## Application for a Non-Material Amendment Following a Grant of Planning Permission

15

Myrtle Avenue

Ruislip

**GENERAL ARRANGEMENT
NON MATERIAL AMENDMENT**

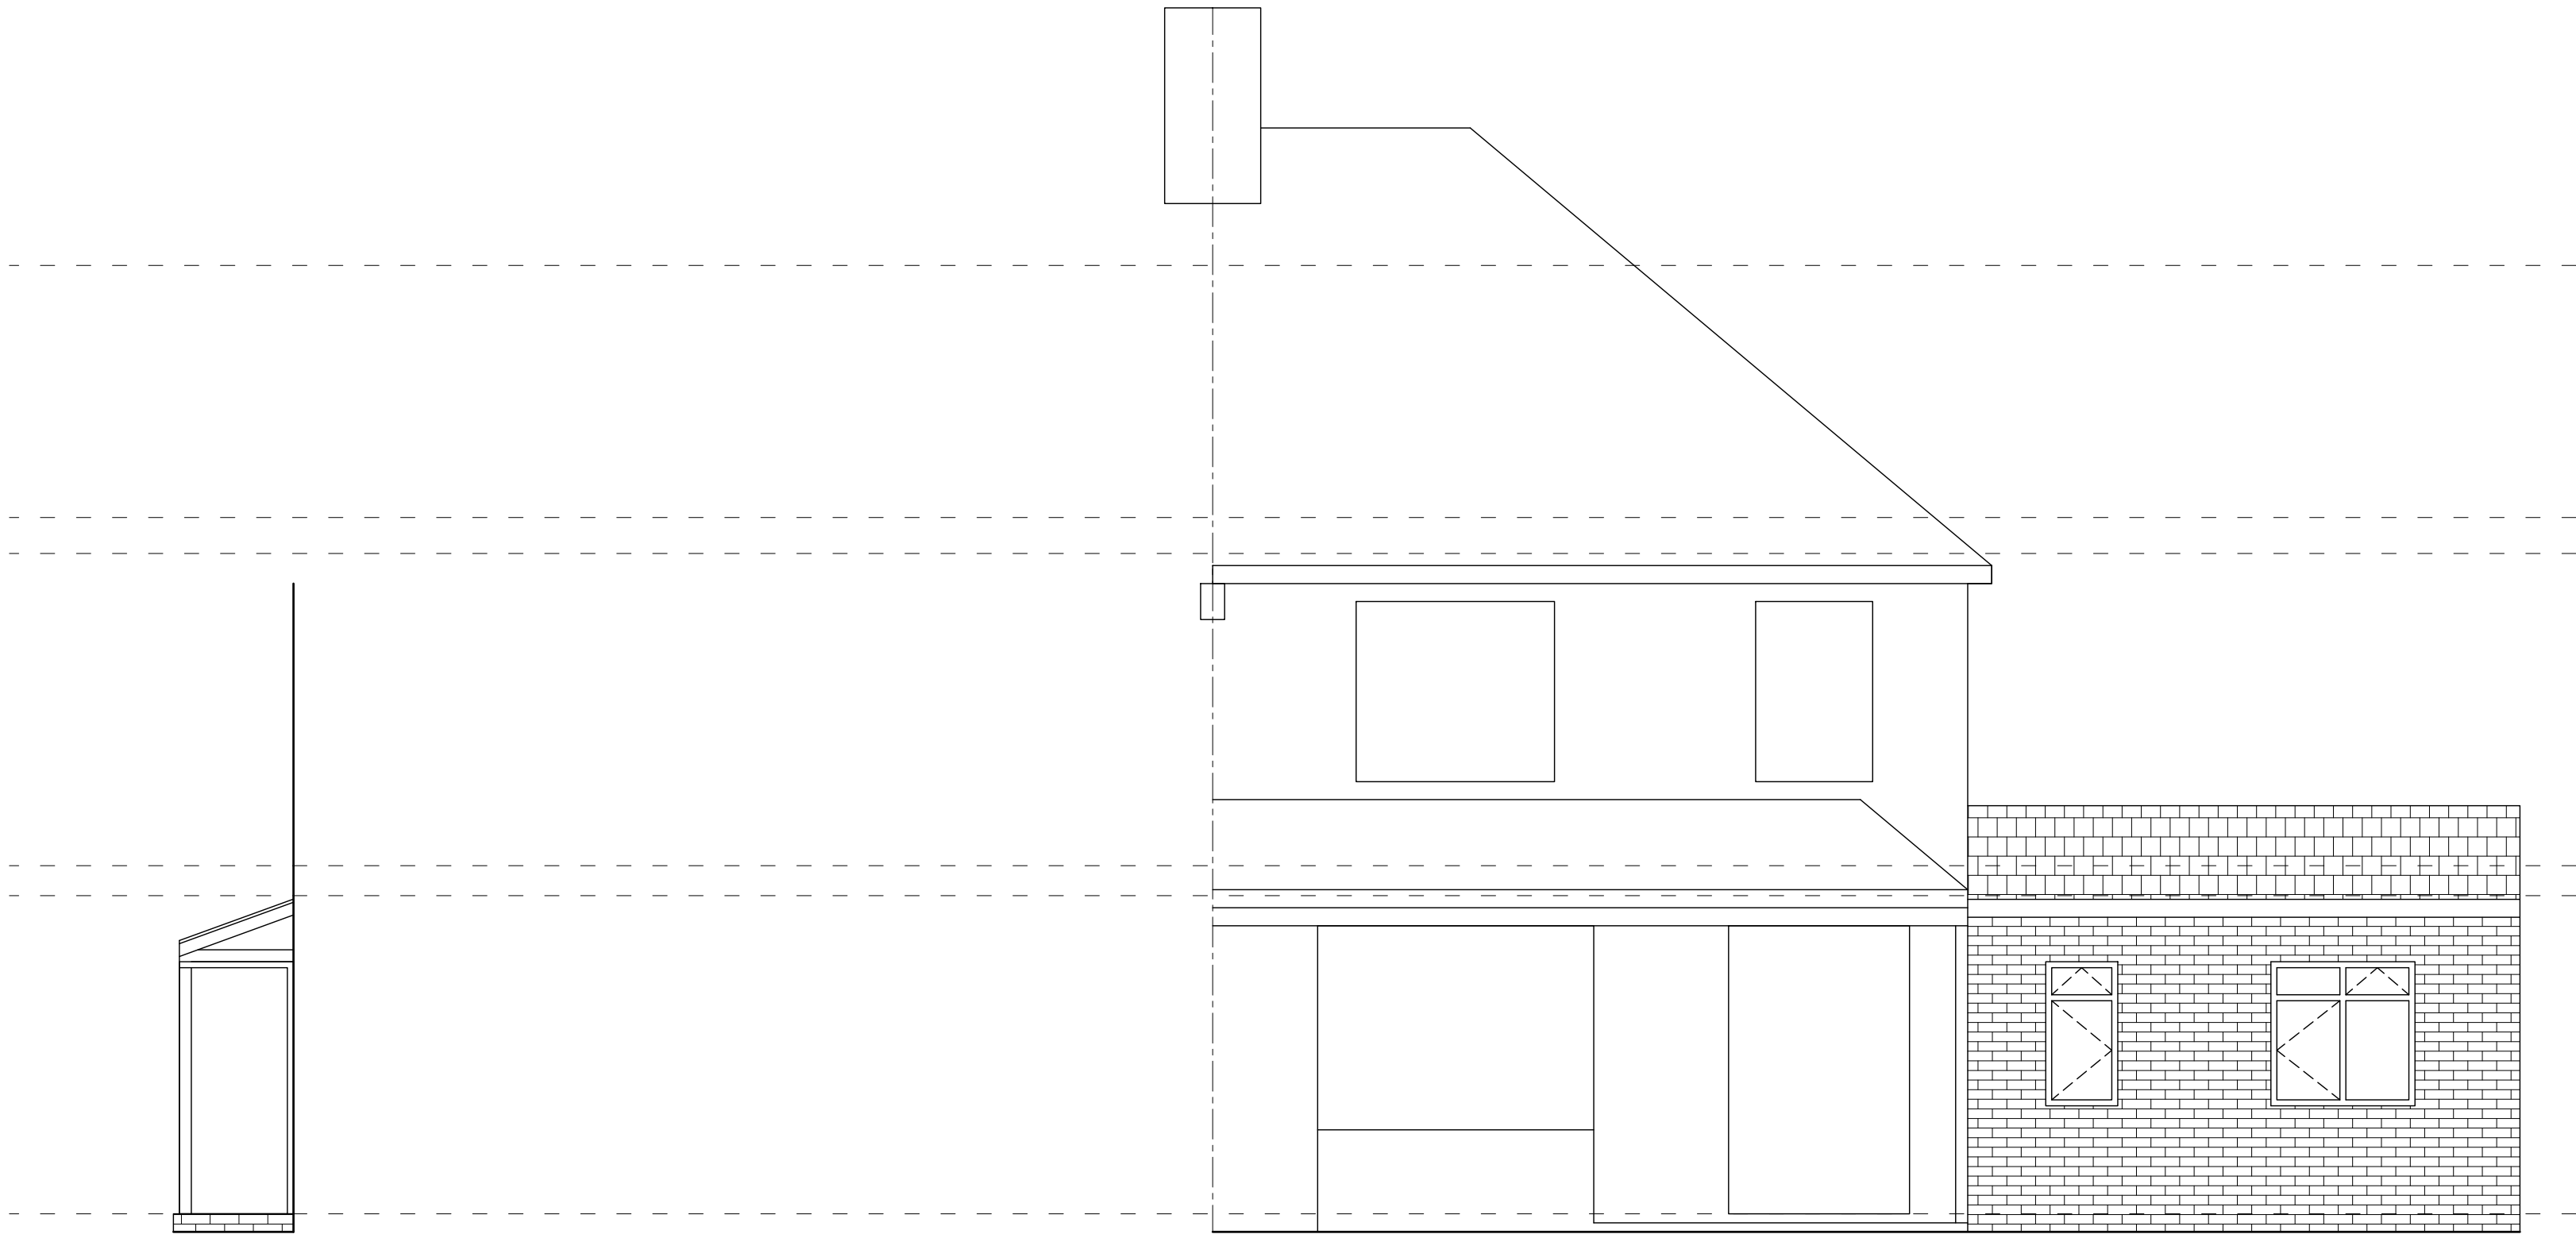
Increase the width of the extension by 200mm and the depth by 100mm. Change hip ended dummy pitch roof to gable end.

To allow sufficient space for a kitchen island. To avoid the flat roof from projecting beyond the side off the dummy pitch roof.
